The Planning Inspectorate
Yr Arolygiaeth Gynllunio

Acceptance of Applications Checklist

Cottam Solar Project Section 55 Acceptance of Applications Checklist

Works Plans
 Sheet 17 of 19

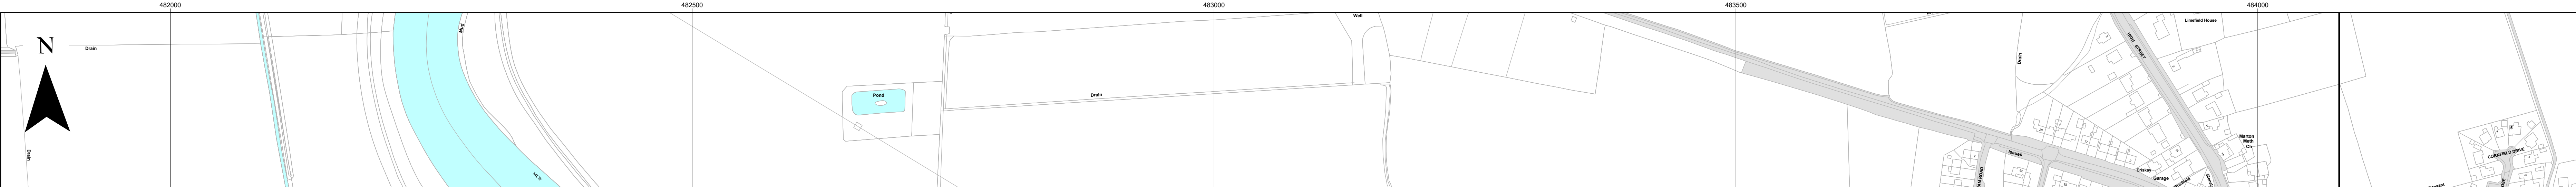
- It has been noted that there are inconsistencies between the **Work Plan (Doc C2.4)** and the **Draft Development Consent Order (Doc C3.1)**. Different classification systems have been used in the **Work Plan (Doc C2.4)** and the **Draft Development Consent Order (Doc C3.1)**. For example: Sheet 14 – Work No 2(h) noted in key but marked as 2(viii) on plan)
- Work No 2 in Schedule 1 of the **Draft Development Consent Order (Doc C3.1)**.notes (a – i) but can only see 2(h and viii) on plan (2 a, b, c, d, e, f and g do not appear to be on the plan)
- Work No 3 in Schedule 1 of the **Draft Development Consent Order (Doc C3.1)**.notes (a – i) but can only see 3(viii) on plan (3 a, b, c, d, e, f, and g do not appear to be on the plan)
- Work No 6A (viii) on Sheet 10 – noted in key plan but cannot see on plan
- Work No 7A noted in key plan on sheet 15 but not on plan

- Work No 9A noted in key plan on sheet 8 but not on plan
- Work No 9B noted in key plan on sheet 19 but not on plan
